**General Amendments**

## **Siting Amendments**

drawing
4B6P House with garage - Sheet 1 Private Layout With all elevation treatment types

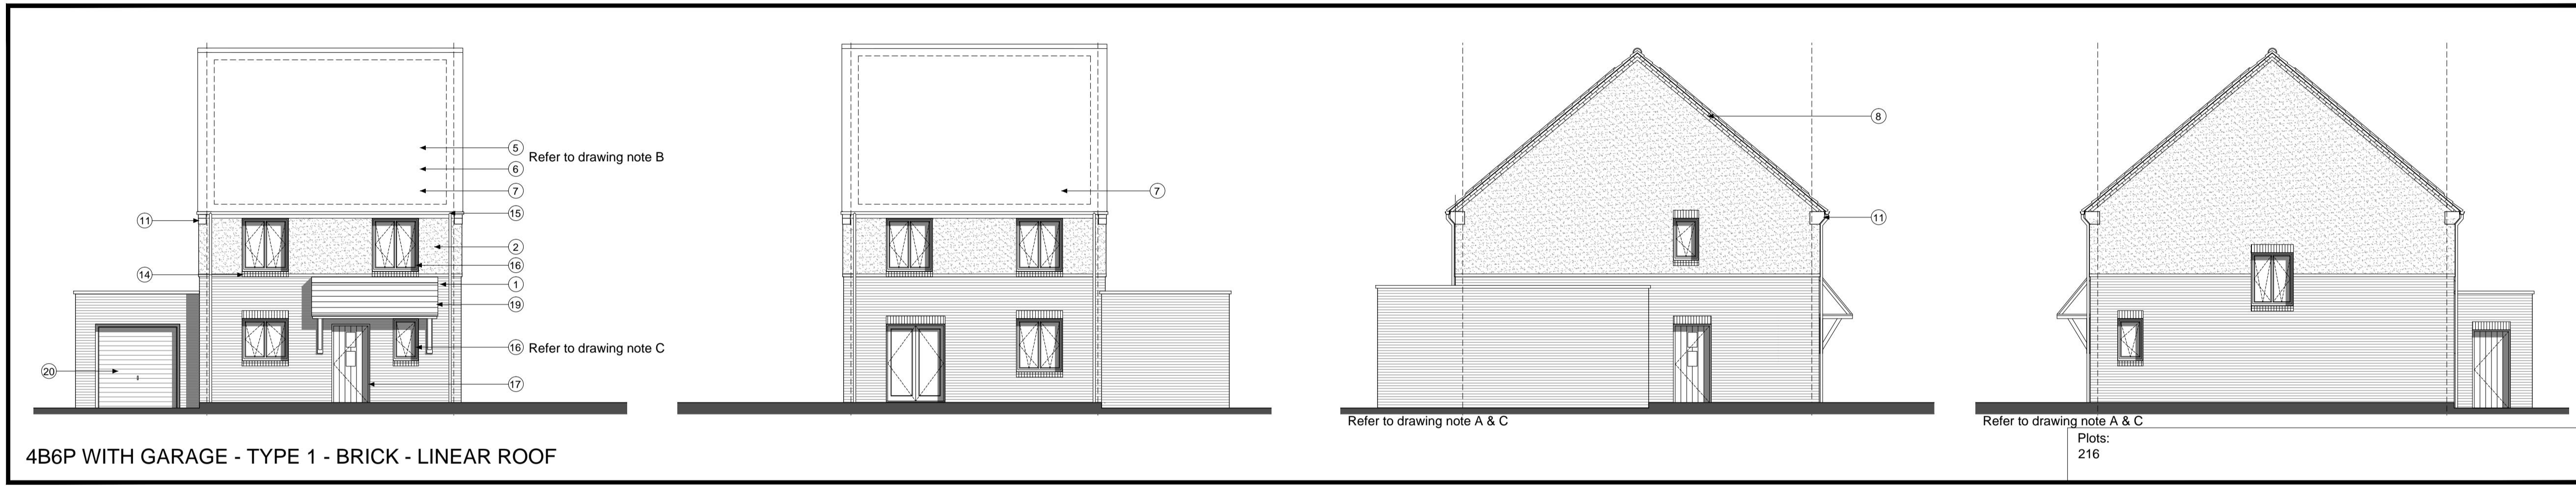
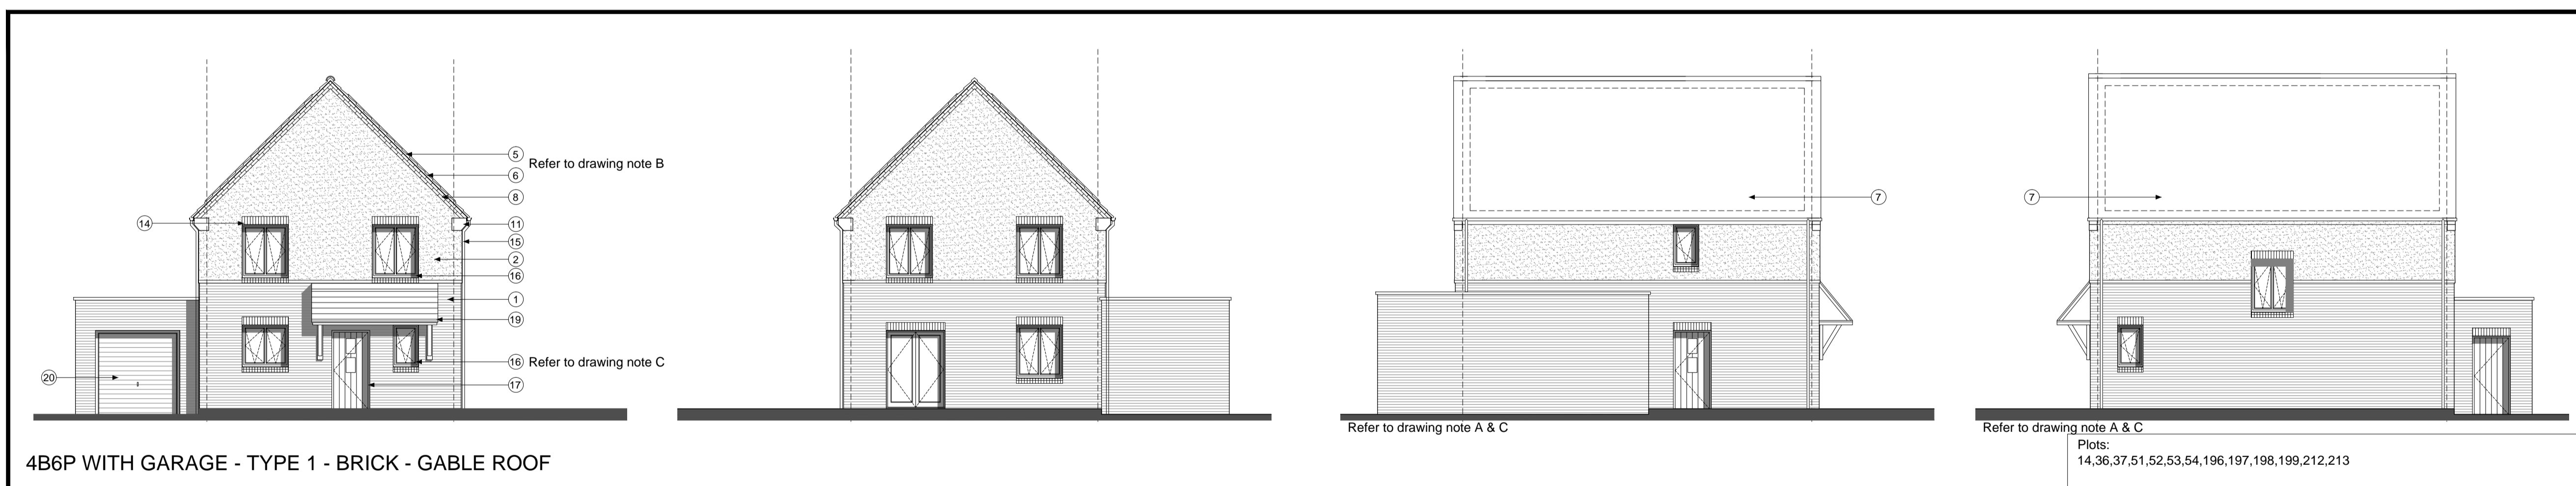
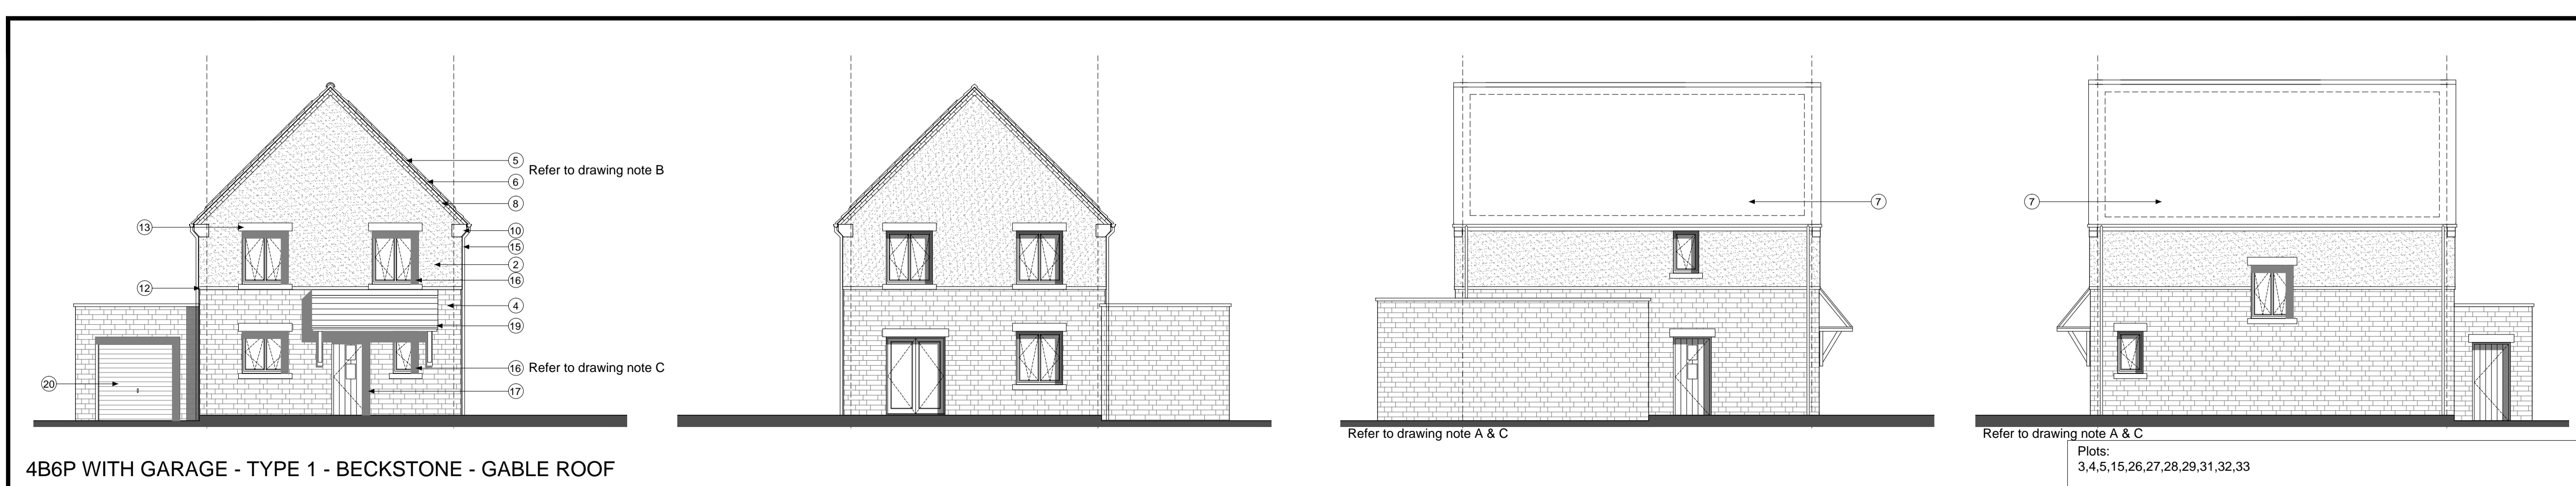
<b>Amendment</b>	<b>Location/Plots</b>
Amendment from Character Type 5 to Character Type 1.	Plots 1,3,4,5,10,11,12,13,14,35,36,37,56,57,58,59,196,197,198,199,208,210,212,213,214,225
Amendment from Character Type 5 to Enriched units.	Plots 15,26,27,28,29,31,32,33,51,52,53,54,60,61,62,63,64,65
Amendment from Character Type 3 to Character Type 1.	Plots 67,68,143,144
Amendment from Character Type 3 to Enriched units.	Plots 135,136
Amendment from Enriched to Character Type 1 units.	Plots 49 & 218

<b>Amendment</b>	<b>Location/Plots</b>
Plots 2,30,195,226,227 have been amended to brick.	Plots 2,30,195,226,227
Amendments from Timber to Brick.	Plots 13,14,49
Amendments from Timber to Timber and Beckstone.	Plots 16,83,124,125,126,135,136,137,167
Amendments from Timber to Timber and Render.	Plots 17,18,19,44,45,46,47,48,55,69,70,71,72,73,84,85,86,87,88,89,90,91,100,101,102,103,104,105,116,117,118,119,127,128,129,130,131,132,133,134,138,153,154,155,156,157,158,159,163,164,165,166,176,177,178,179,180,184,185,186,187,188,189,202,203,204,205,206,207,215, 221,222,223,224
Amendments from Render to Brick	Plots 34,50,56,57,58,59,67,68,195,196,197,198,199,208,213,214,
Amendments from Render to Timber and Beckstone.	Plots 15,26,27,28,29,31,32,33,51,52,53,54,60,61,62,63,64,65

<b>Amendment</b>	<b>Location/Plots</b>
Amendments from Gable fronted to Linear fronted roof type.	Plots 24,25,49,143,144,195,208,209,214,225,
Amendments from Linear fronted to Gable fronted roof type.	Plots 72,73,211,218
Plots 2,30,195,226,227, have been amended to a standing seam metal roof.	Plots 2,30,195,226,227
Plots 210 & 228 have been amended to slate roofs.	Plots 210 & 228
